**Marist Catholic College North Shore Redevelopment (SSD-10473)  
Request for Additional Information**

I refer to the state significant development application for the redevelopment of Marist Catholic College North Shore (SSD-10473). In addition to the issues raised in the letter dated 29 March 2021, the Department of Planning, Industry and Environment (Department) has identified a determinative issue with the proposed child care centre as detailed below.

Figure 1 – Proposed childcare fitout floorplan

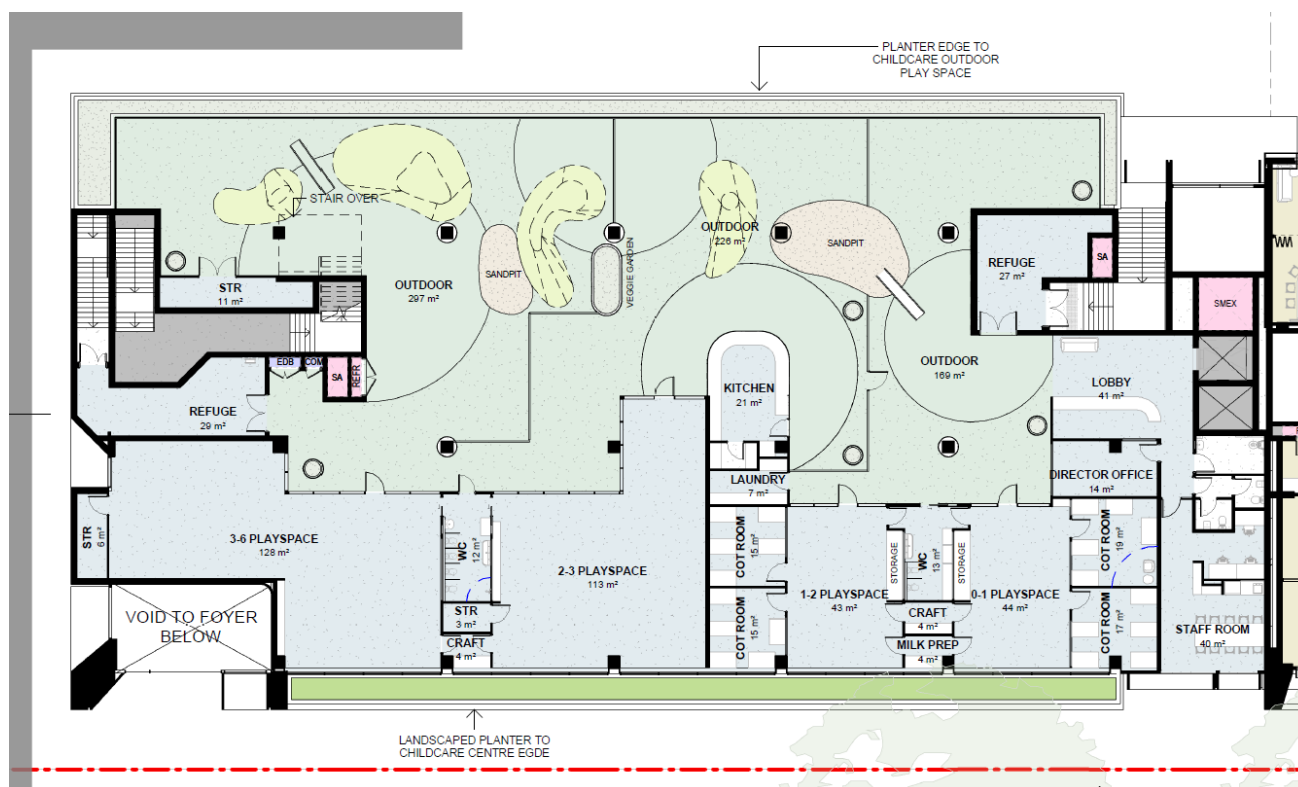
The proposed child care centre is located on level 1 of the Miller Street Building with approximately 674sqm of simulated outdoor space within its internal footprint. The space marked as "outdoor" on the submitted architectural drawings is located entirely within the building. The space is enclosed and is not open to the elements. Throughout the Environmental Impact Statement (EIS) the subject space is referred to as simulated outdoor space. Therefore, in accordance with Clause 22 of the Education SEPP, the proposal requires concurrence from DoE.

In response to this issue originally raised by the Department on 21 April 2021, an email was received from Ethos Urban on 26 April 2021 stating that the design of the western façade of the Miller Street building has not been fully developed. A section sketch was provided showing proposed design amendments including the provision of a vergola over a small portion of the space and fixed screens at the balustrade line. These proposed amendments would not result in 630 sqm of unencumbered outdoor space being provided as the subject area would still be predominantly enclosed. Consequently, the Department will not accept these proposed amendments as satisfying the concerns raised above.

2. Amend the proposal so that unencumbered open space can be provided. To achieve this, it is likely that the child care centre will need to be relocated to a different part of the site or building such as the ground floor level. A revised Noise Impact Assessment will be required to be prepared to assess any additional noise impacts from the relocated child care centre and provision of outdoor space. The application may be amended as part of the Response to Submissions (RtS) under this option; or

3. Remove the child care centre from the proposal and use level 1 as part of the school or a use ancillary to the school. Relevant details of the proposed alternate use of level 1 of the building are required to be provided including any additional impacts and permissibility (if relevant). The application may be amended as part of the RtS under this option.
